REQUEST

Current Zoning: N1-A (neighborhood 1-A)
Proposed Zoning: R-12MF(CD) (multi-family residential, conditional)

Approximately 19.91 acres located on the east side of North Tryon Street, east of Pavilion Boulevard.

The petition proposes a residential community containing a maximum of 200 multi-family dwelling units and, any incidental and accessory uses permitted in the R-12MF zoning district.

RZ1.00

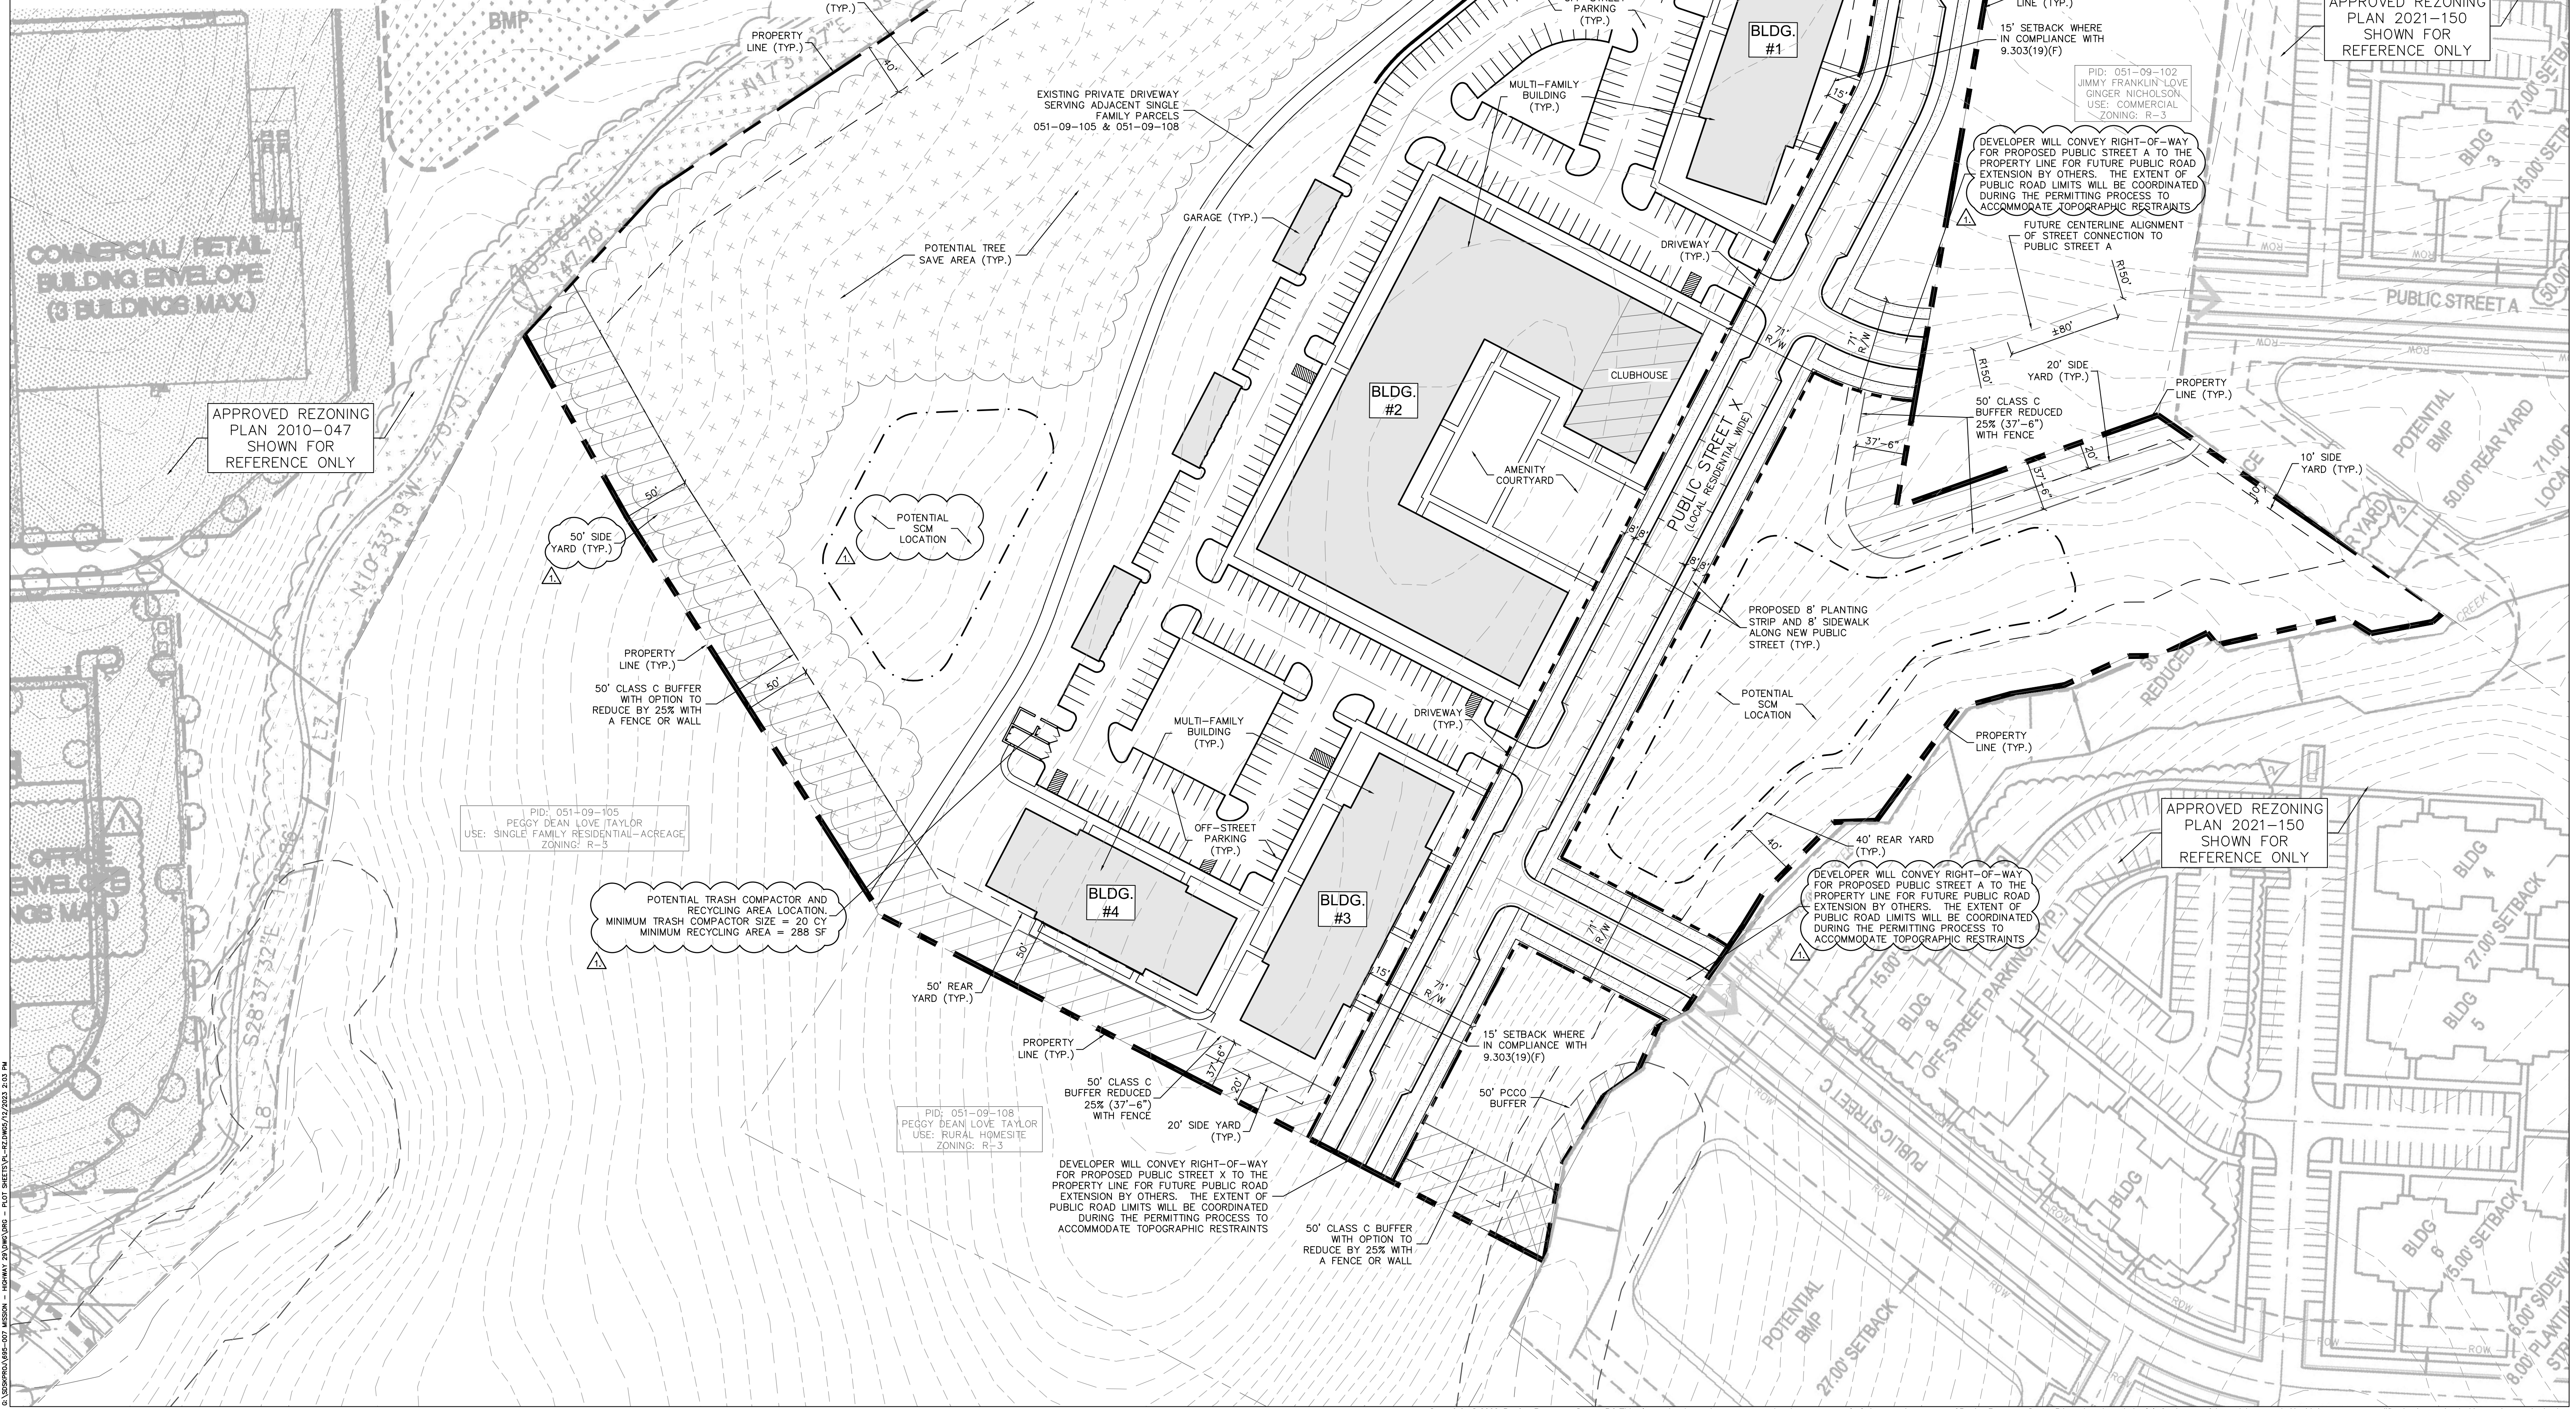
1. — Add a conditional note specifying "All transportation improvements will be approved and constructed before the site's first building certificate of occupancy is issued. The petitioner may phase transportation improvements if said improvements and phasing are explicitly described in site plan notes." Addressed
2. Revise site plan and conditional notes to commit to relocate proposed site access to the west along US 29 and to coordinate site access location and median extension limits with NCDOT. Site plan shall label and dimension the change along with adding conditional notes committing to the coordinating with NCDOT. Addressed
